DRB Application No.: 11DRB-70252 , Project # 1005354
Project Name: ARBOLEA DE VIDA + SAUNDYLL VILLAGE UNIT 2B
Agent: DEKKER PERICH SABATINI Phone No.:

DRB Application No.: <i>11DRB- 70265</i>	Project # <i>1005354</i>
Project Name: <i>Arbolera De Vida Unit 2B. Sawmill Village</i>	
Agent: <i>Dekker Perich Sabatini</i>	Phone No.:

**Re: Reason for Request
Sawmill Village
Request for Amended Site Development Plan for Subdivision
Tract 2-D of the Arbolera de Vida Subdivision, Albuquerque, NM (Phase 2)
Project # 1005354; 07EPC-00109**

**LANDSCAPE PLAN
PHASE II**

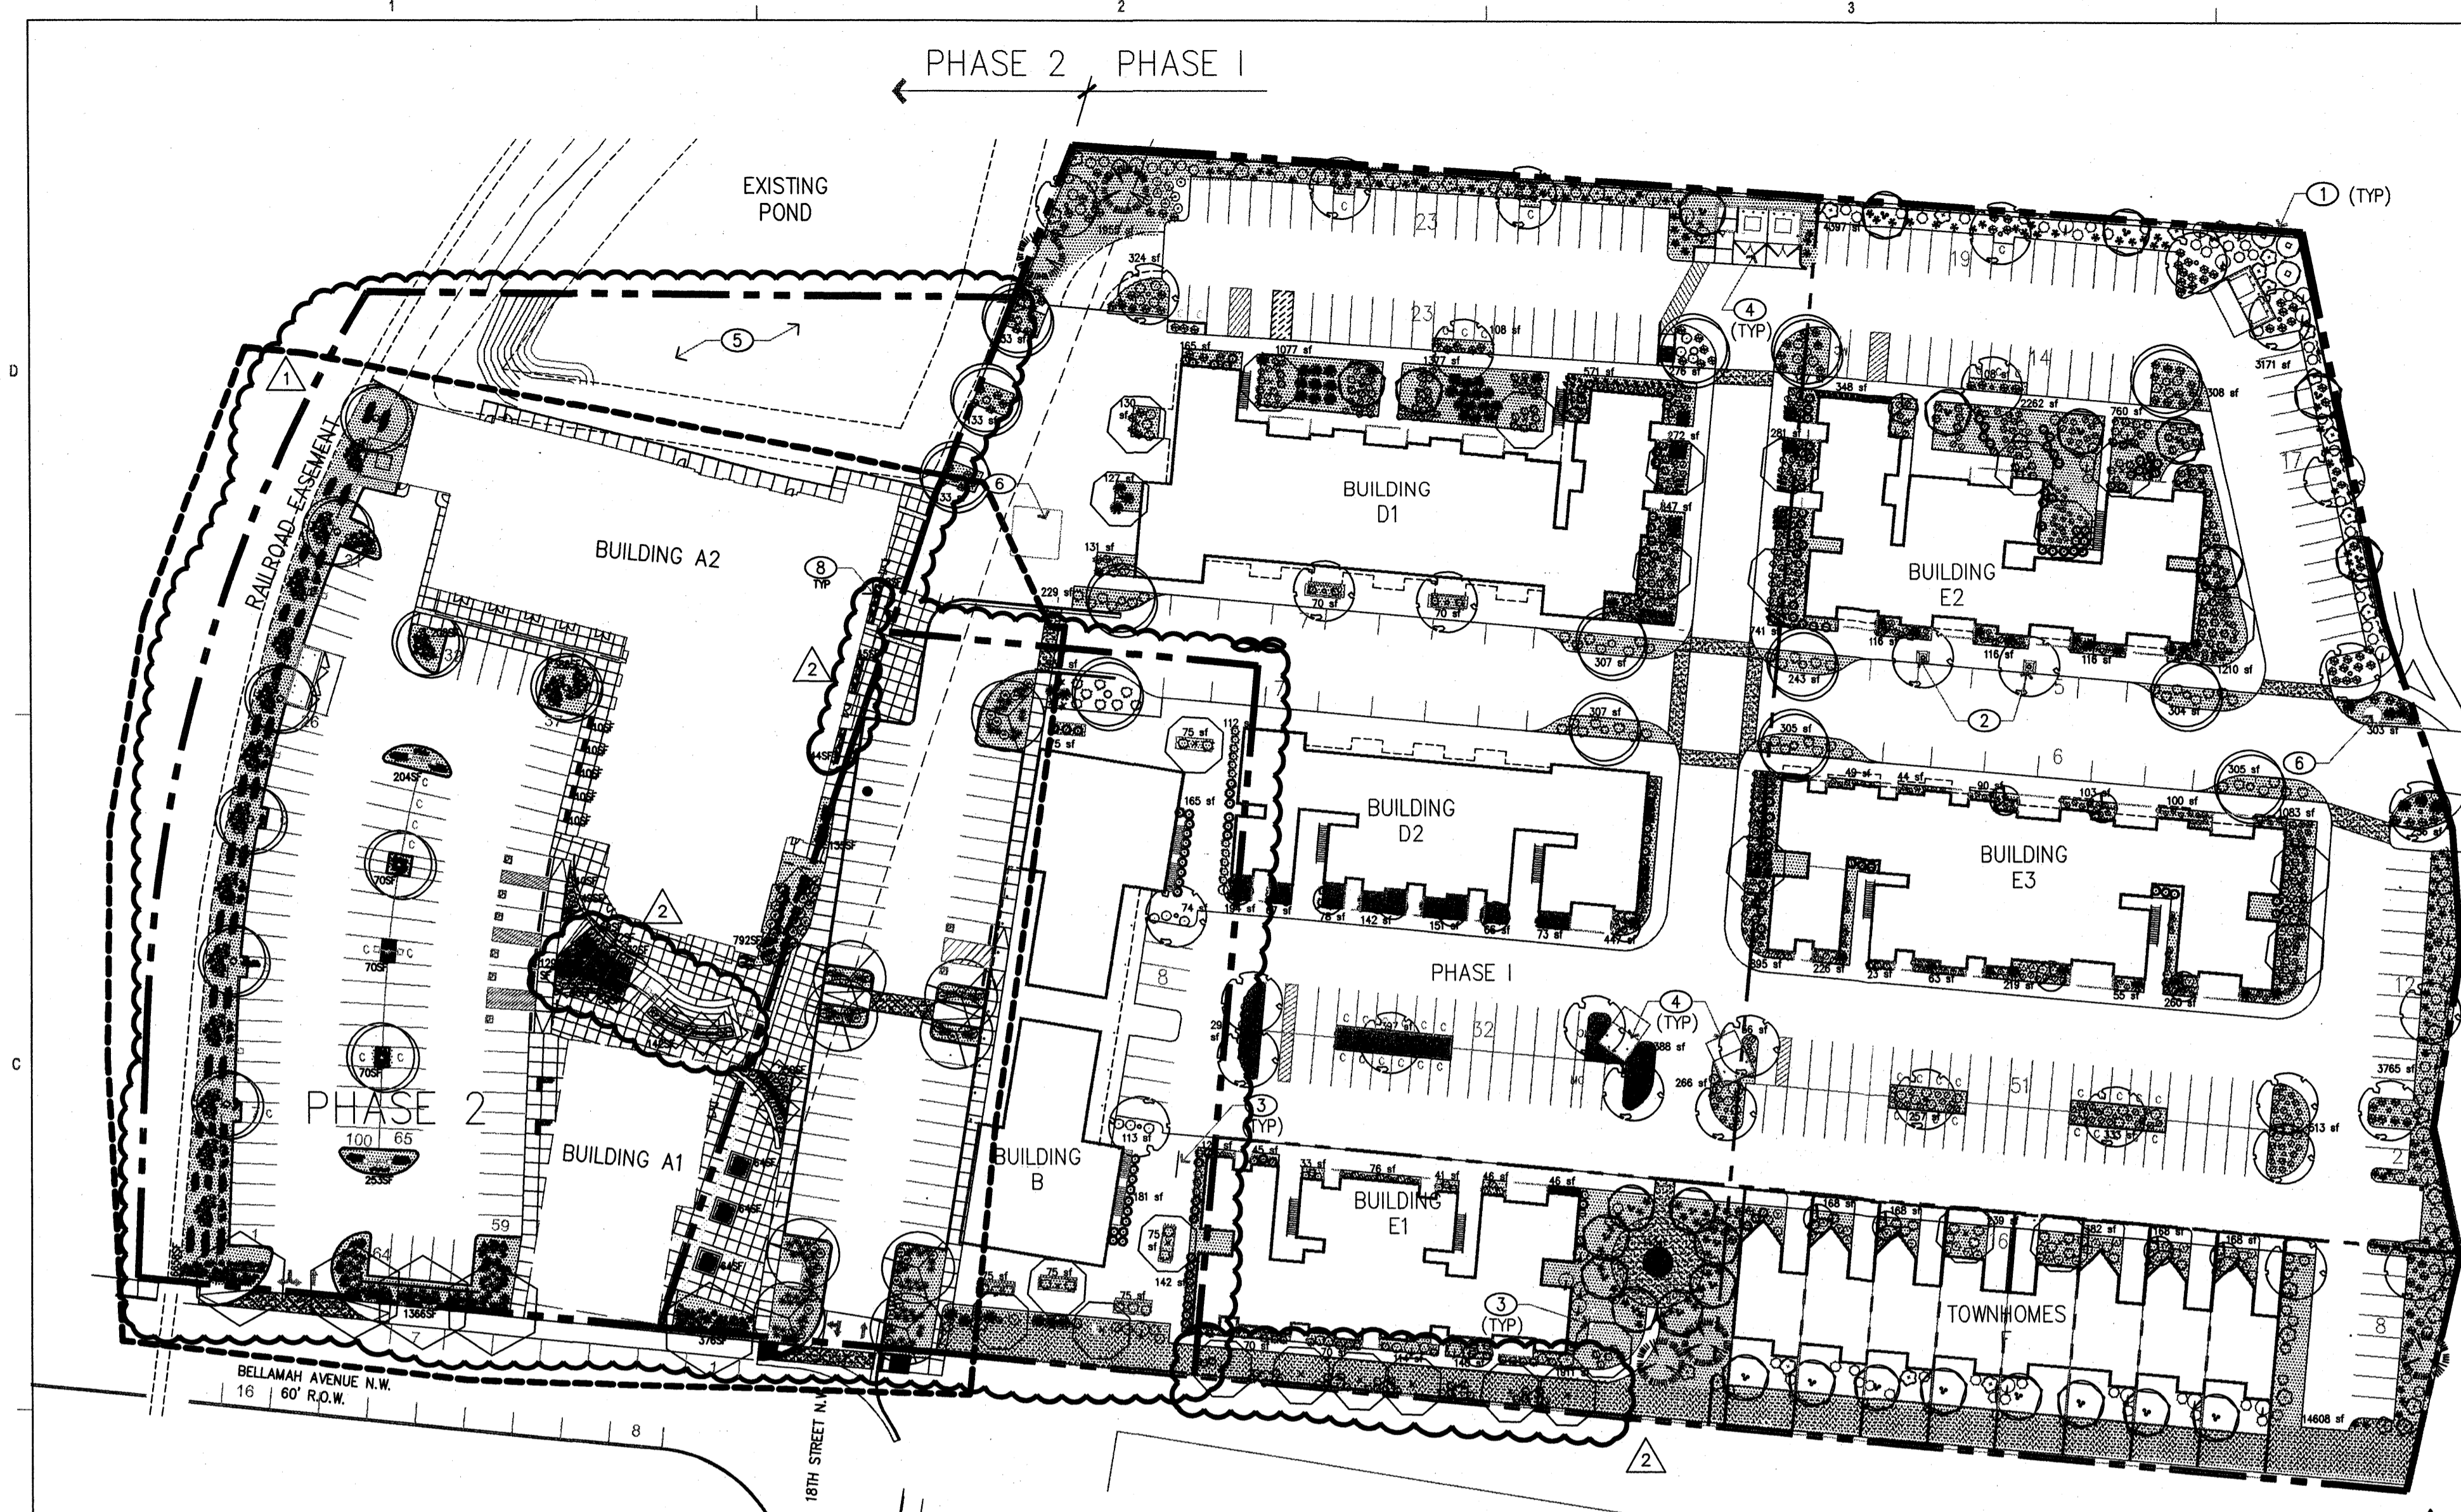
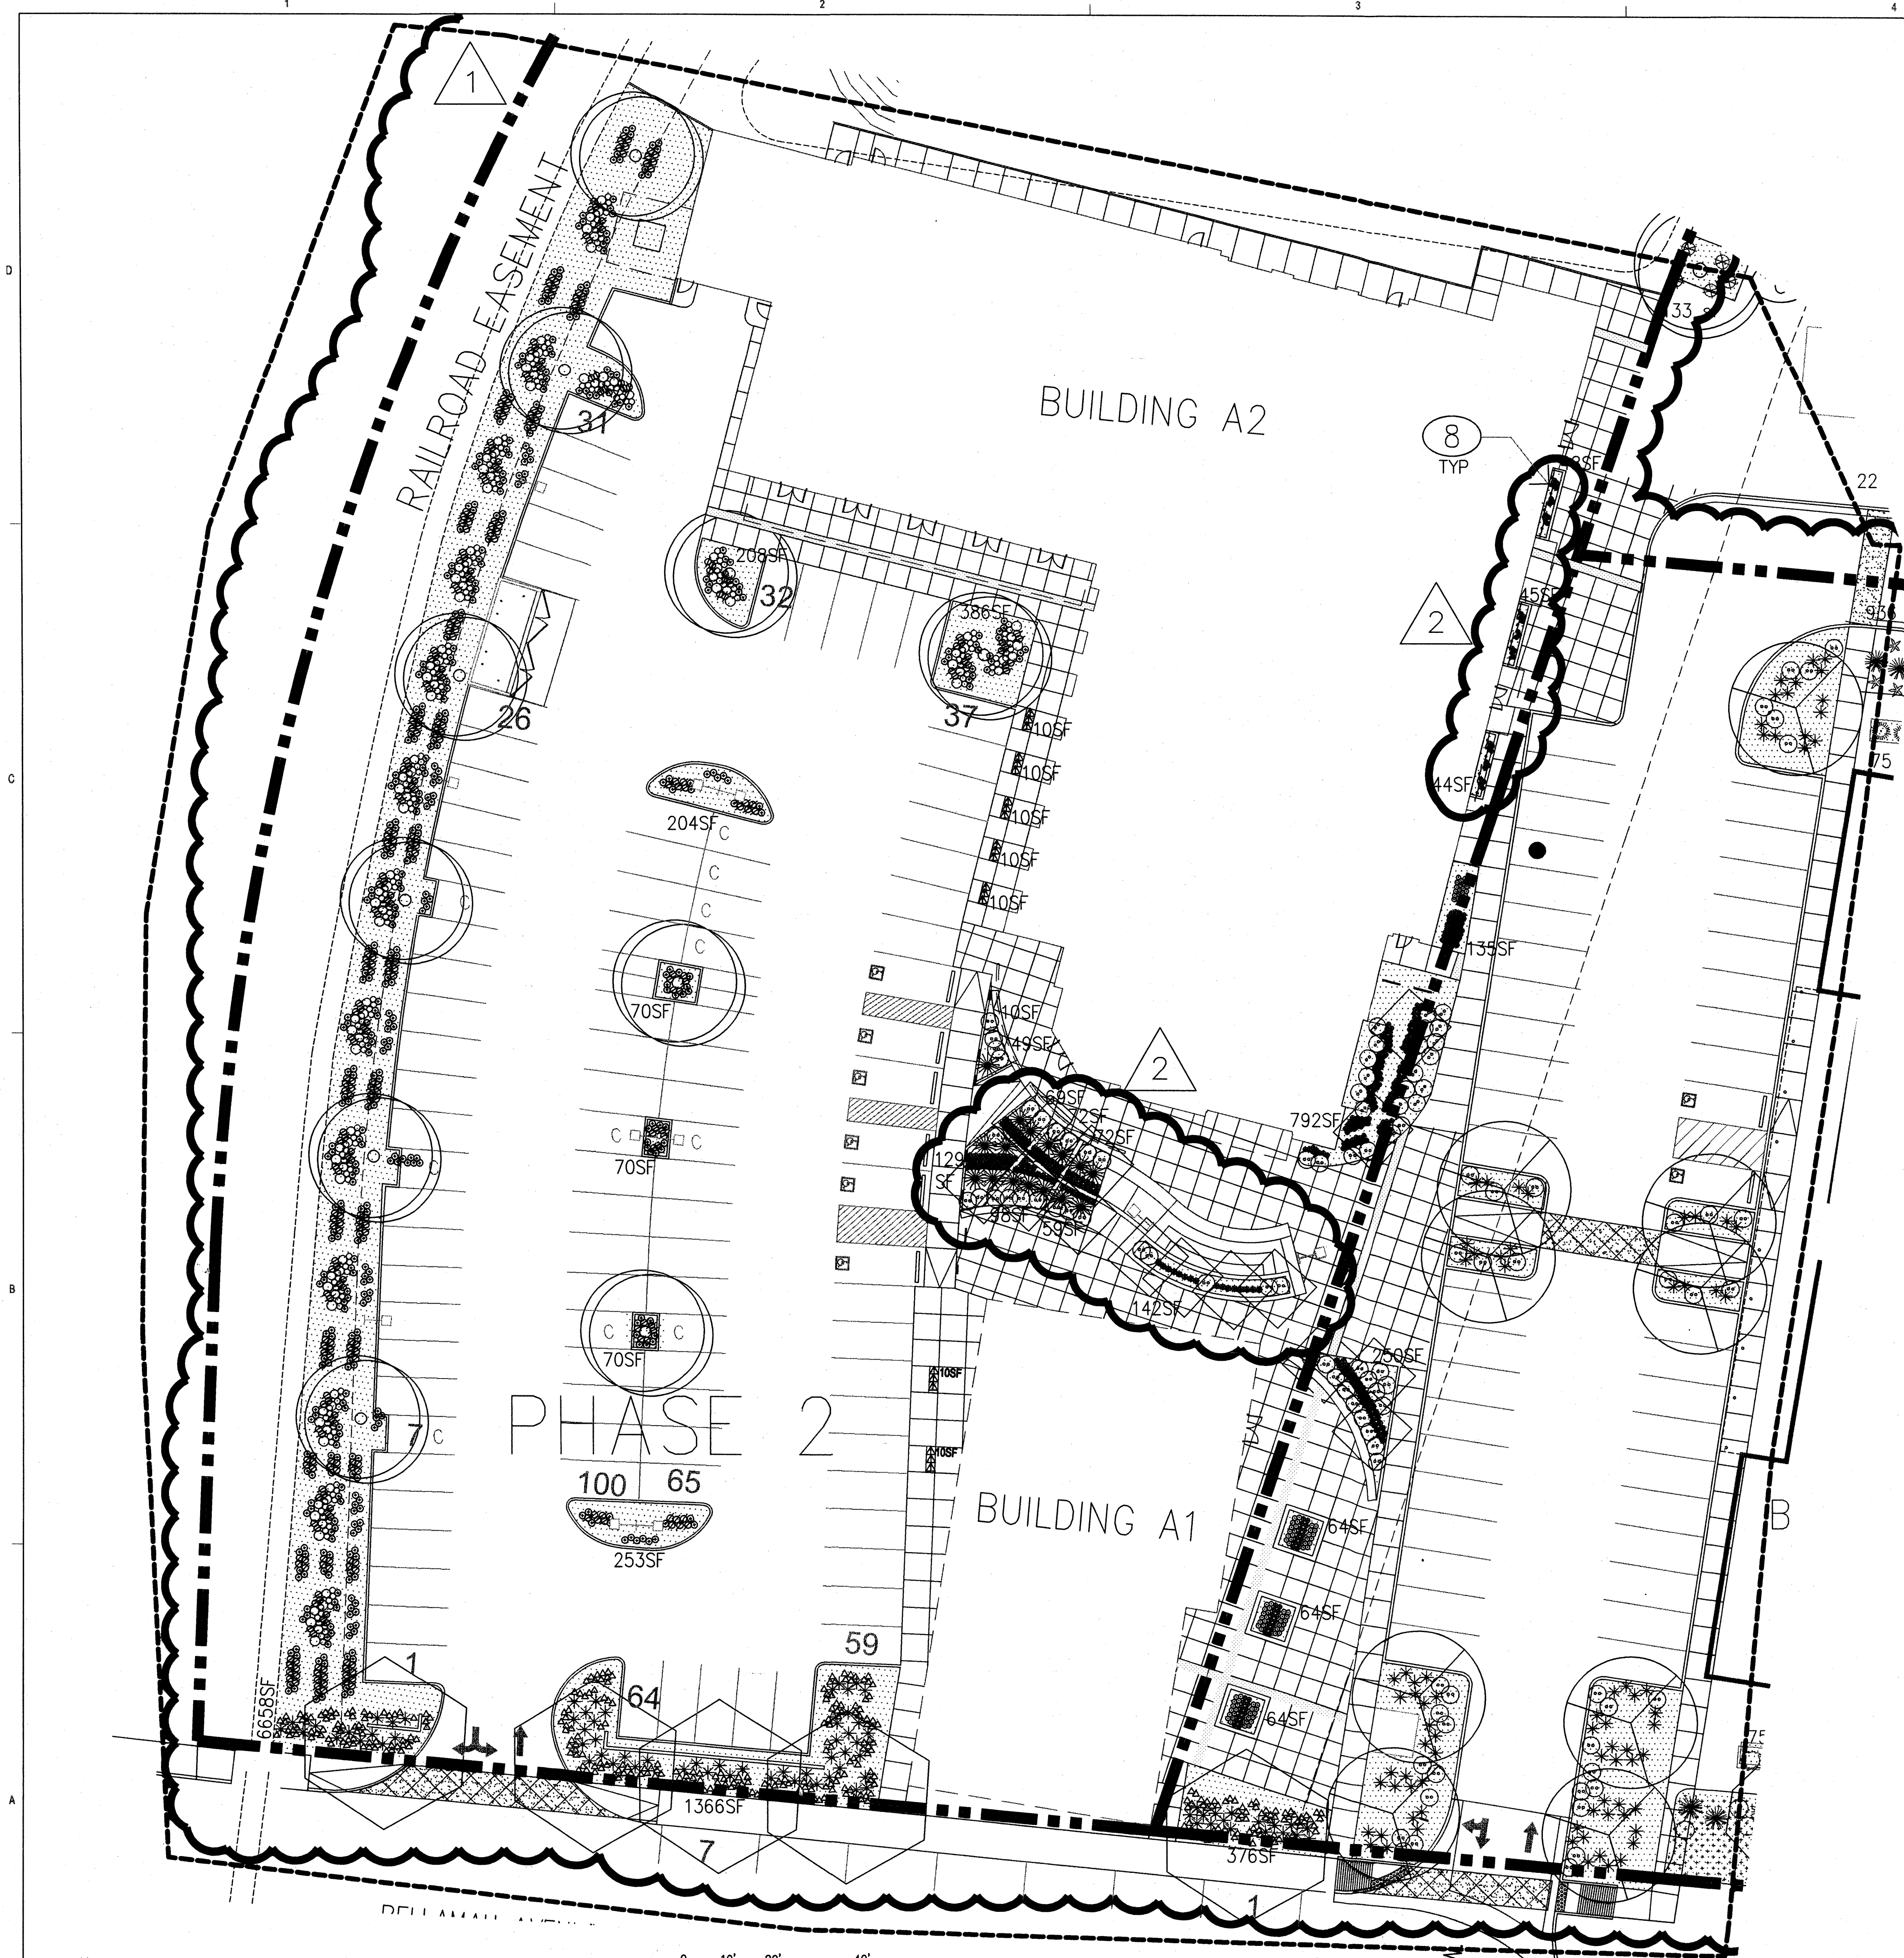
- c. The seat walls around the planters shall be shown.

RESPONSE: The seat walls are shown and indicated by note 8 on SDP2 and SDP2A.

SDP4
3 OF 4

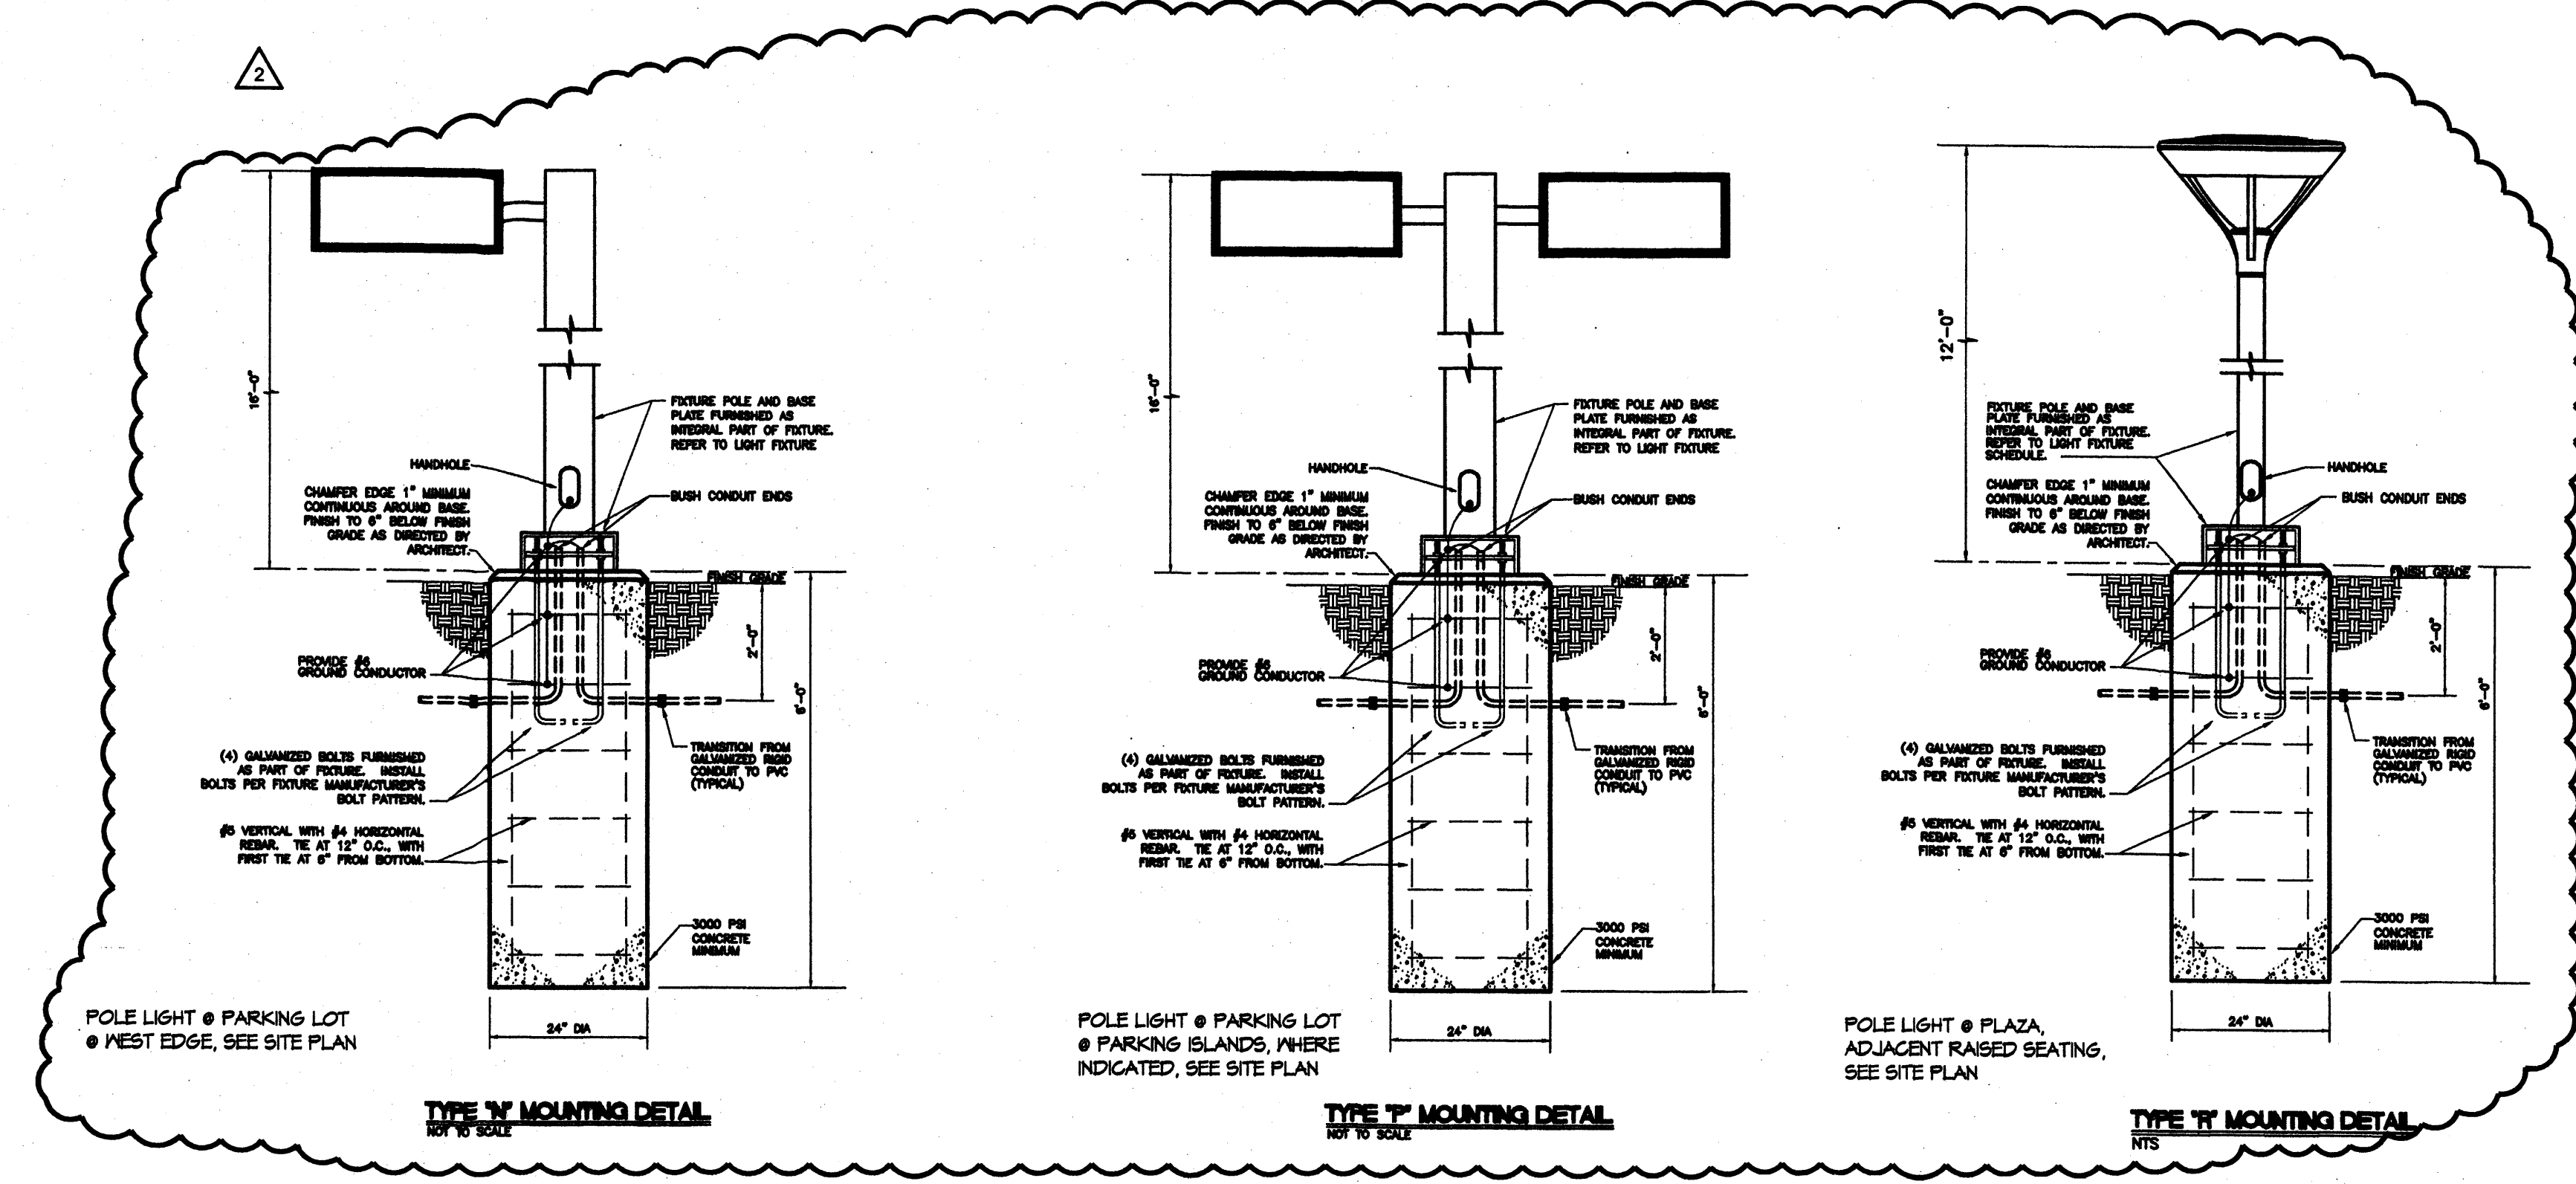
- b. A bicycle rack detail shall be provided.

- a. The color, finish and/or type of block for the screen wall shall be specified.

- b. The location of the fence near the NW corner, and its color, finish and/or type, shall be specified and a detail provided.

- c. The color and finish of the refuse enclosure shall be indicated.

11. **CONDITION:** Lighting: Provide detail for each light pole type.

- a. The letter color and lighting of the monument sign shall be specified.

RESPONSE: A bicycle rack detail has been provided on a detail sheet, SDP4.

RESPONSE: The color is tan. The finish is burnished concrete masonry units and is indicated on the Site Detail Sheet SDP4.

RESPONSE: The site wall is indicated by note 36 and a detail shown on SDP4.

RESPONSE: The color and finish are indicated on SDP4, color: tan, finish: burnished CMU block.

RESPONSE: The light pole types are indicated on SDP4.

RESPONSE: All has been indicated and noted on SDP4.
